Our ref: DECISION
GCC Application Ref: **19/03645/LBA**

SITE: 17 Drury Street Glasgow G2 5AE

PROPOSAL: Internal and external alterations and display of signage.

PLANNING DECISION NOTICE

JOB TITLE	DATE	SCALE	DRAWING NO.
MITCHELLS & BUTLERS THE HORSE SHOE BAR GLASGOW	22.11.19	1:50 @ A1	JMDA 1486/105B
DRAWING TITLE: PROPOSED WALL FINISHES / CURTAINS			
NOTE: THIS DRAWING TO BE PRINTED IN COLOUR FOR CLARITY			
DRAWN BY: ES		DRAWING NO: JMDA 1486/105B

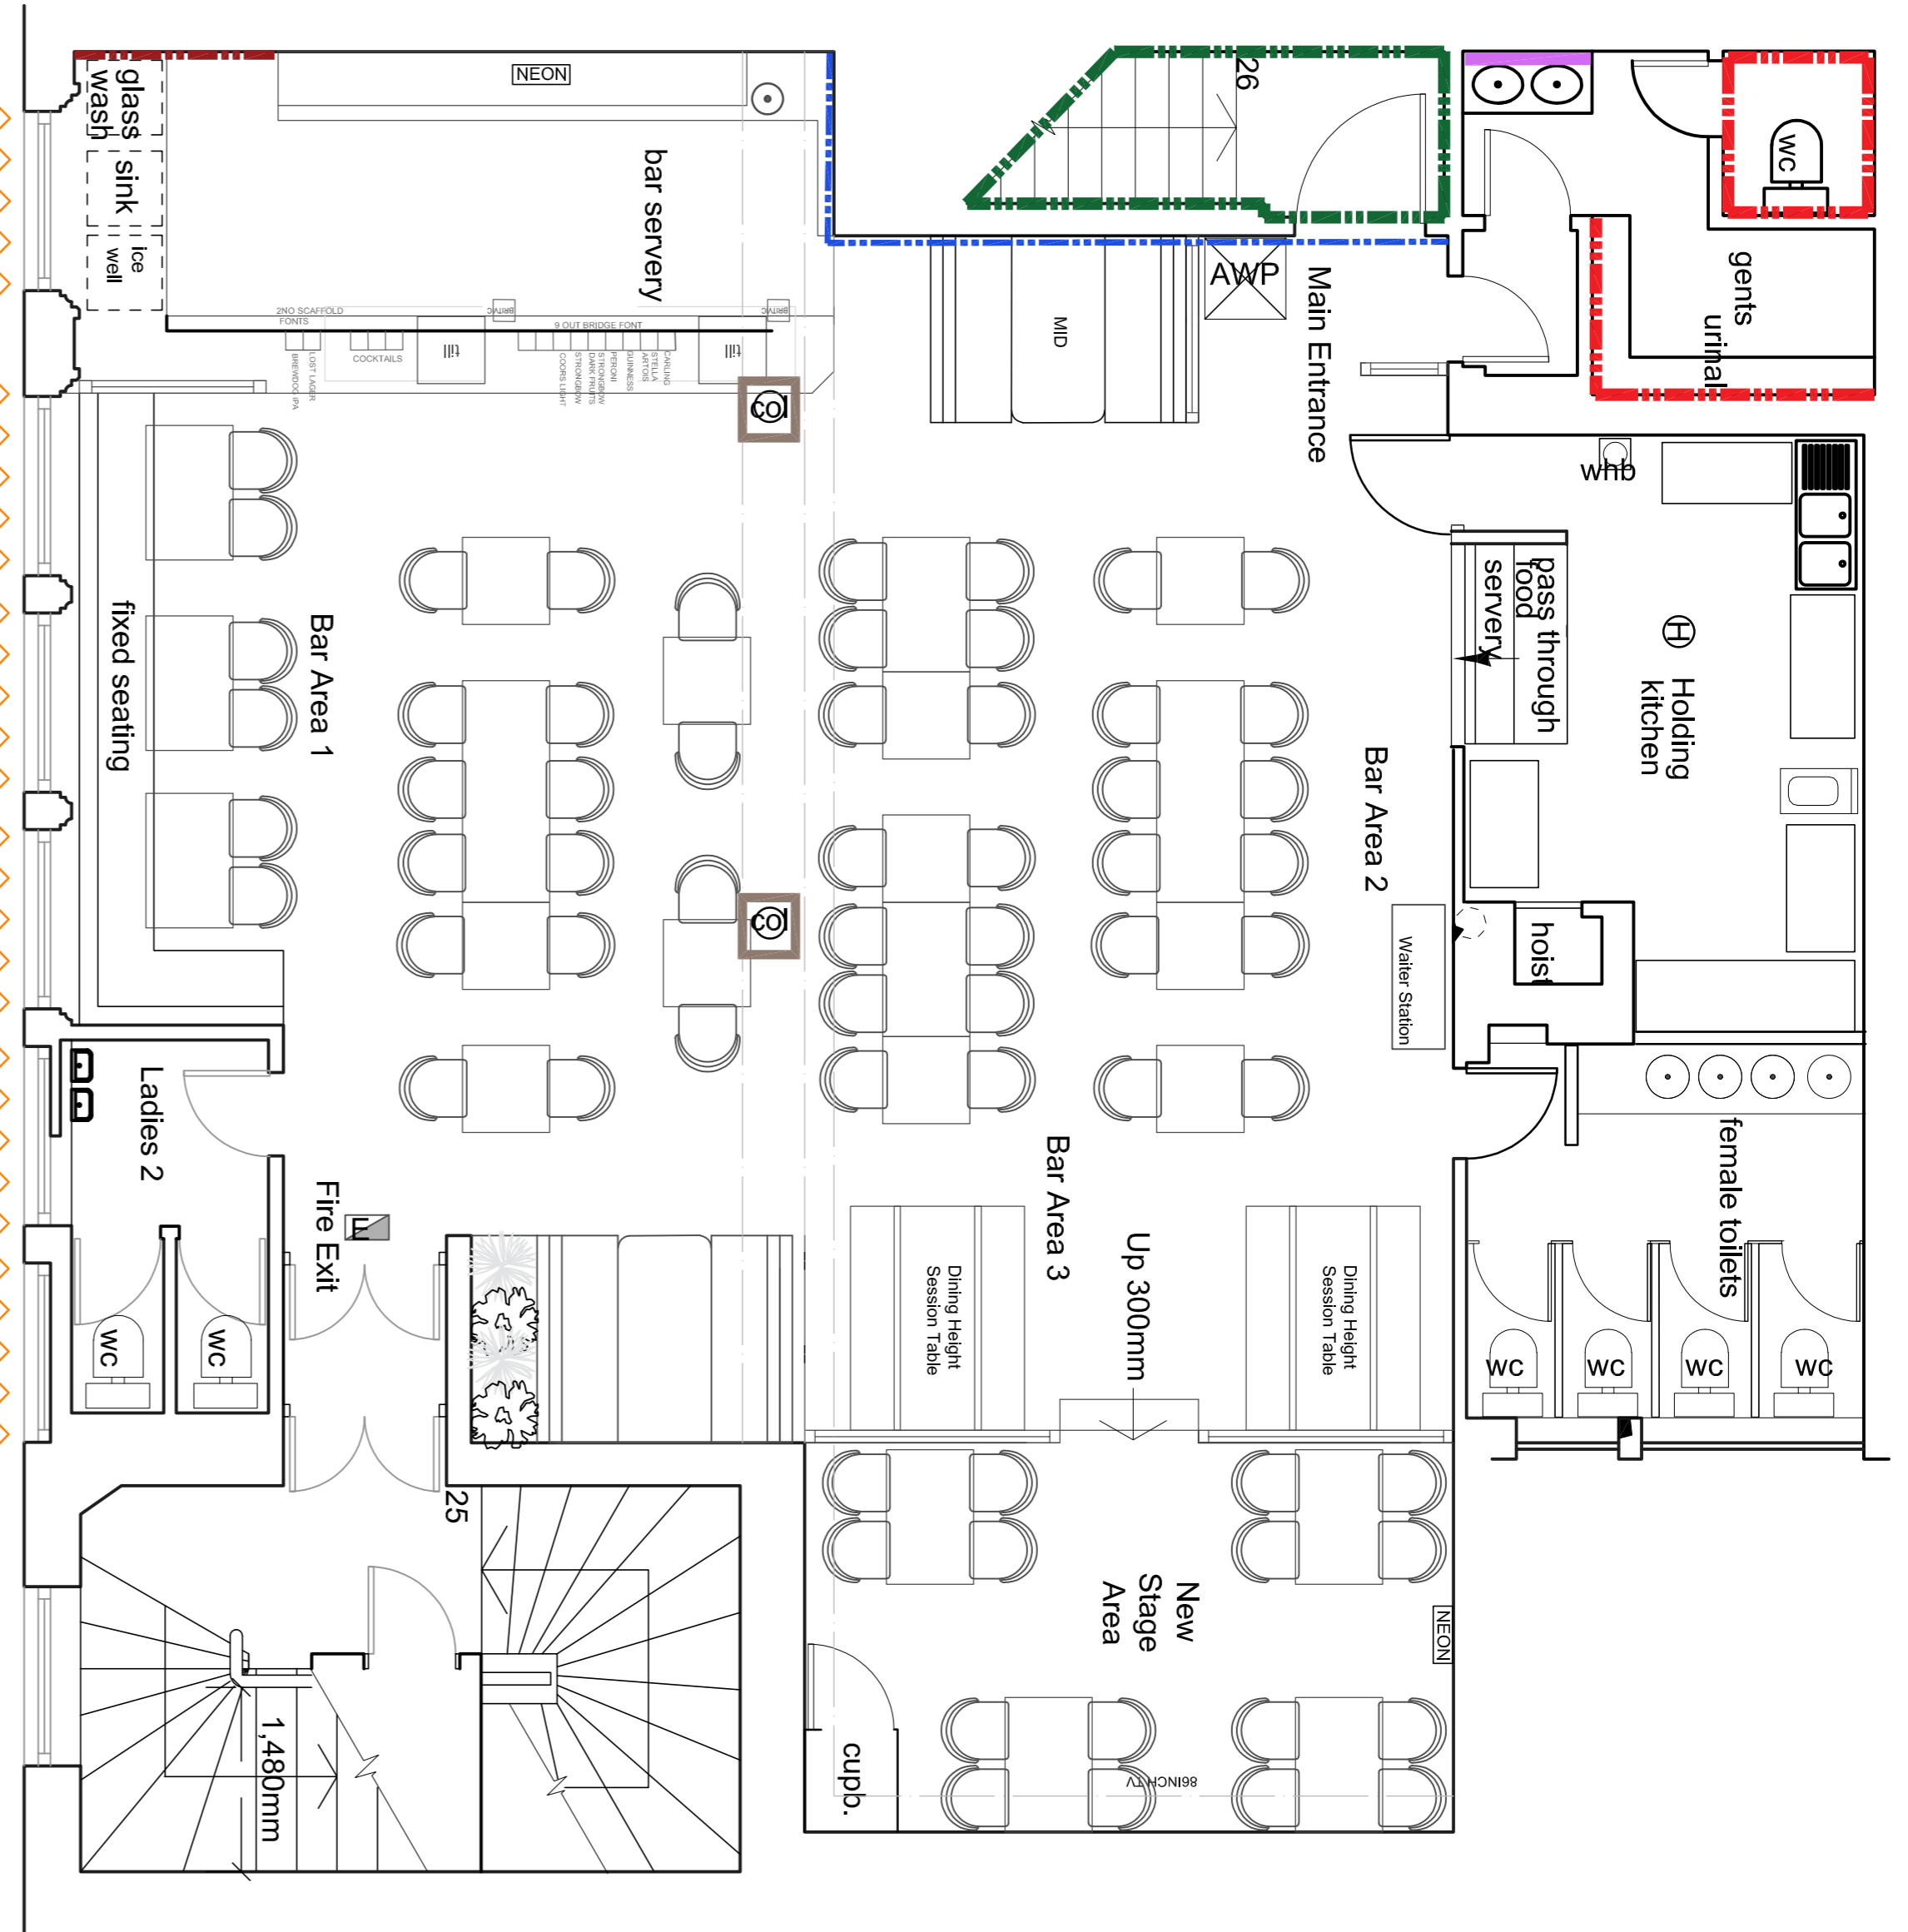
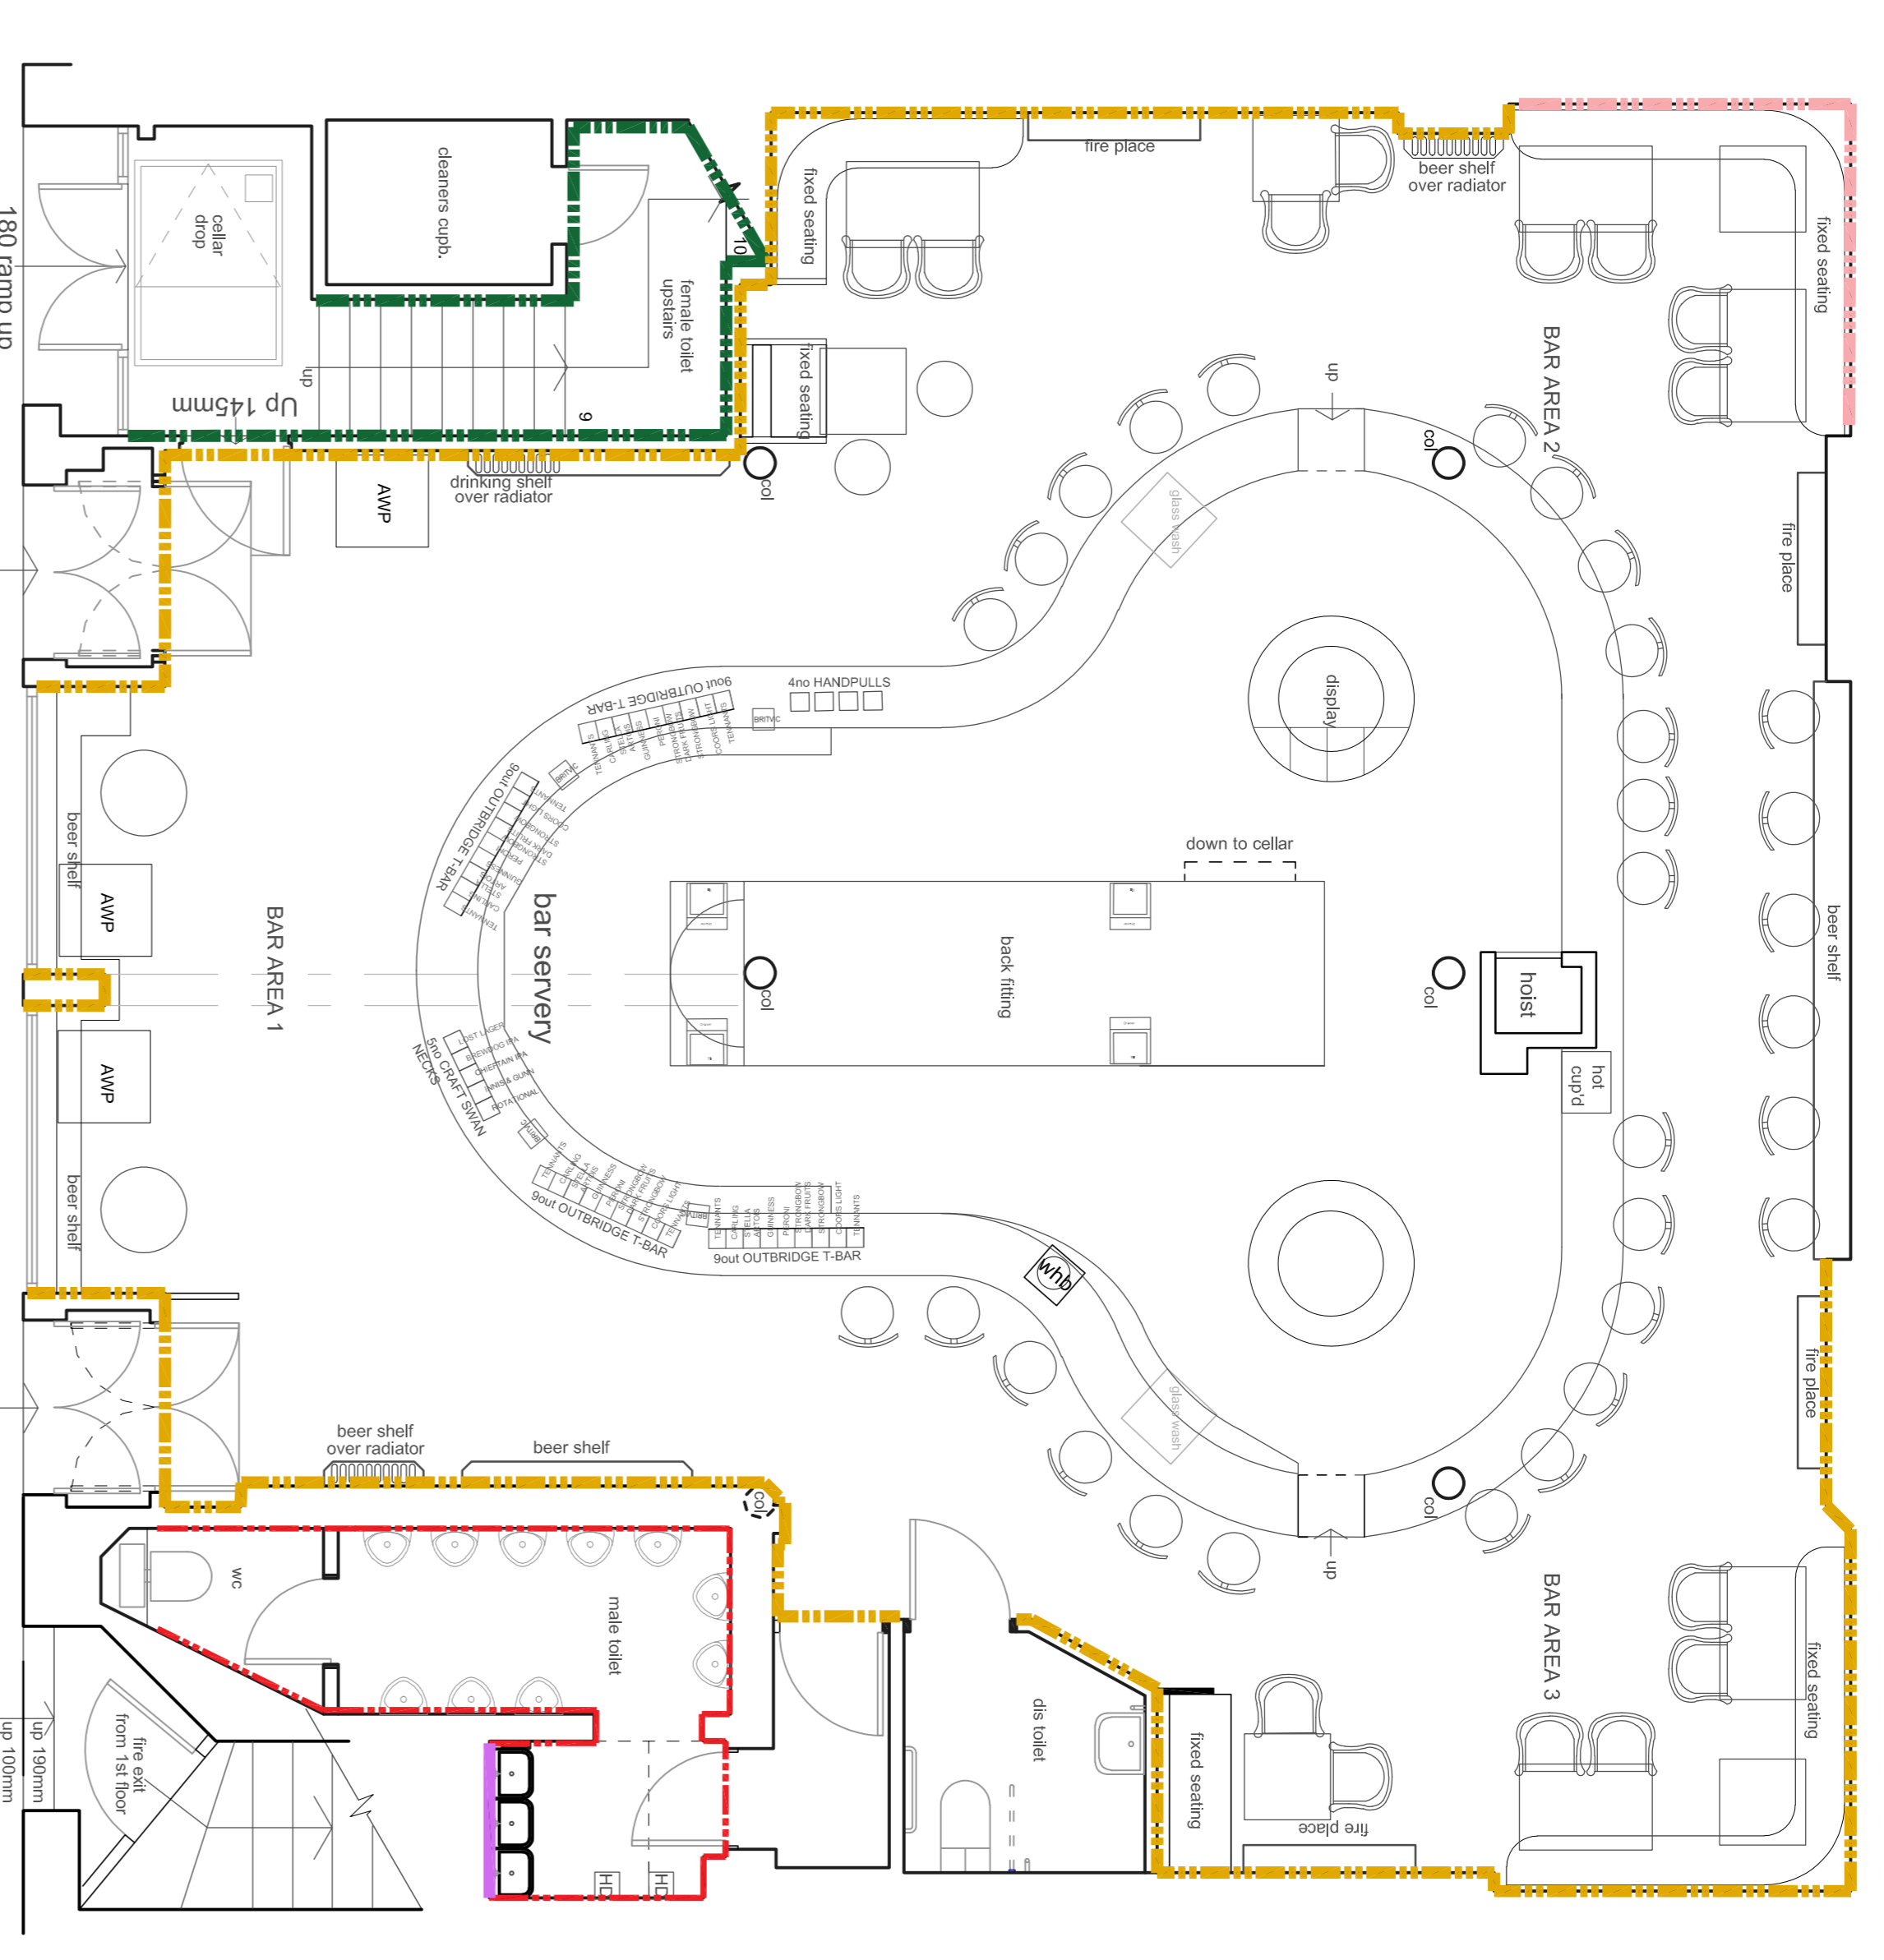
01. For the avoidance of doubt the proposed wall coverings to the first floor are hereby not approved. A revised scheme of decoration for the first floor area shall be submitted to and approved in writing by the Planning Authority prior to this element of works commencing.

DRAWING TITLE
EXTERNAL ELEVATIONS

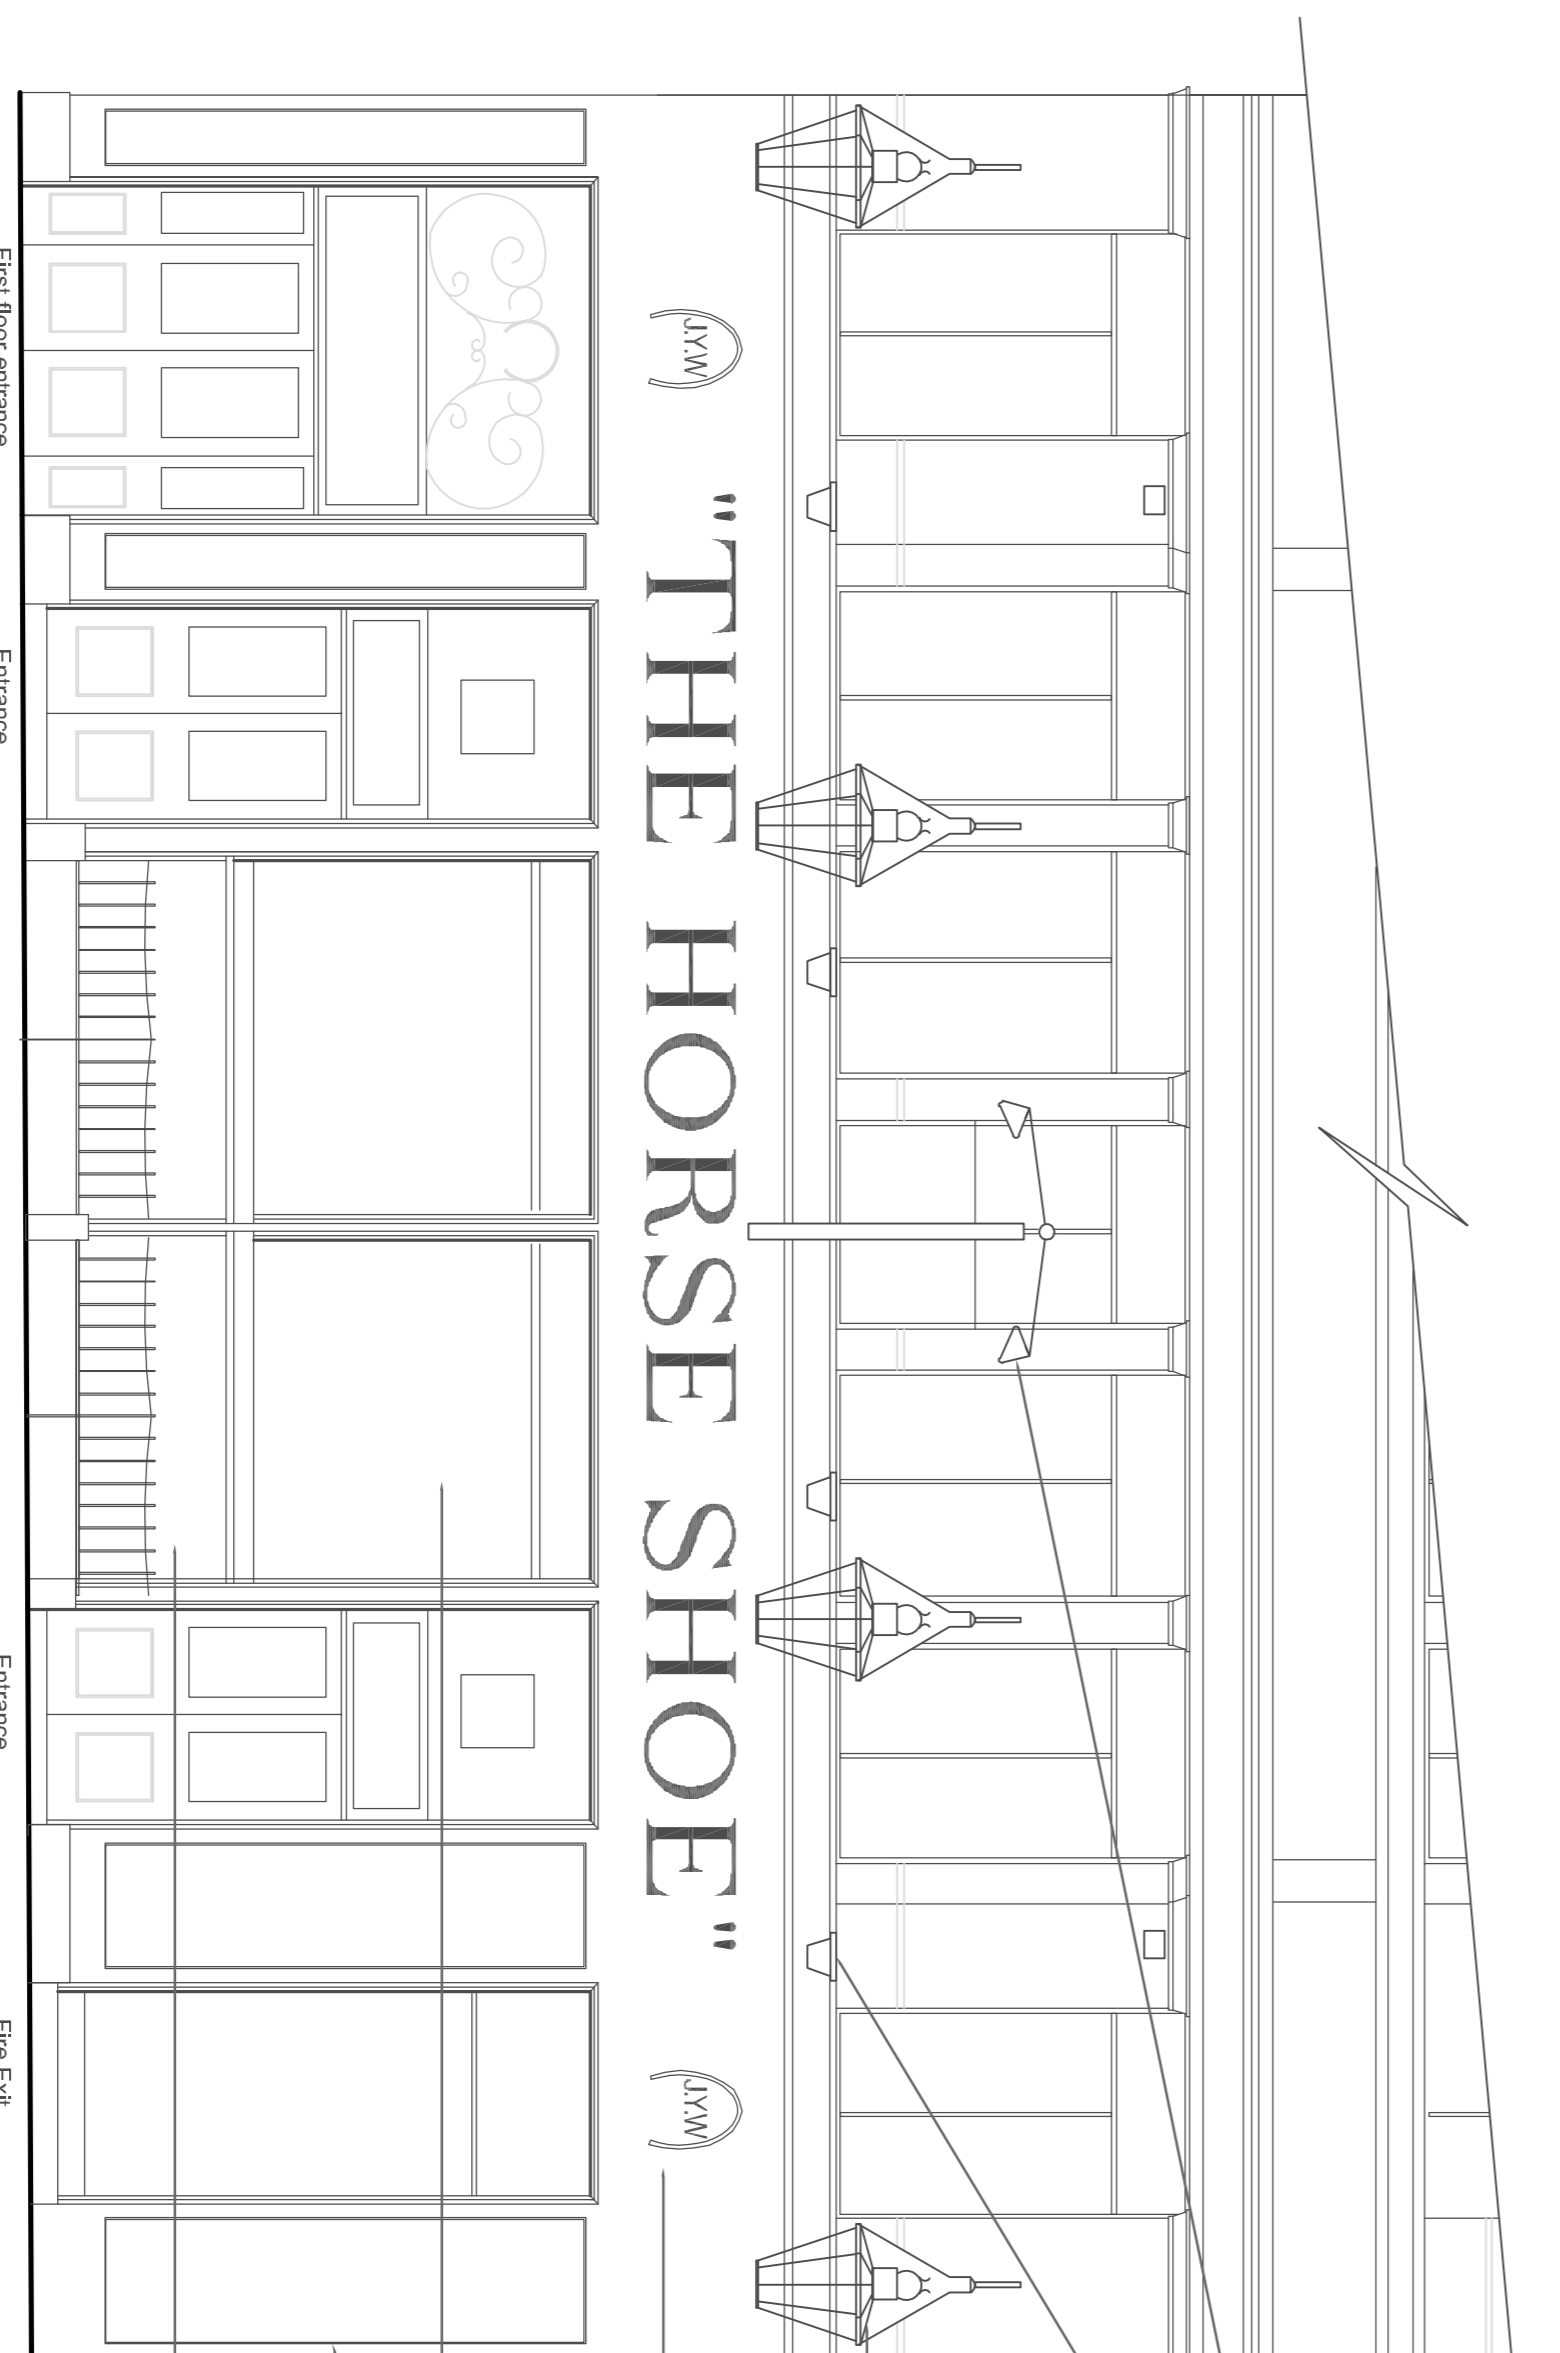
Reason: To safeguard the character of the listed building.
03. For the avoidance of doubt the proposed floodlights on the frontage are hereby not approved. Further details of the proposed lighting installation, including the type, dimensions, locations and colour of fittings, cable routes and associated electrical equipment shall be submitted to and approved in writing by the Planning Authority prior to being installed onto the building.

Reason: To safeguard the character of the listed building and the character of the surrounding conservation area.
04. All external colours shall be approved in writing by the planning authority before they or any relevant materials are used on the site.
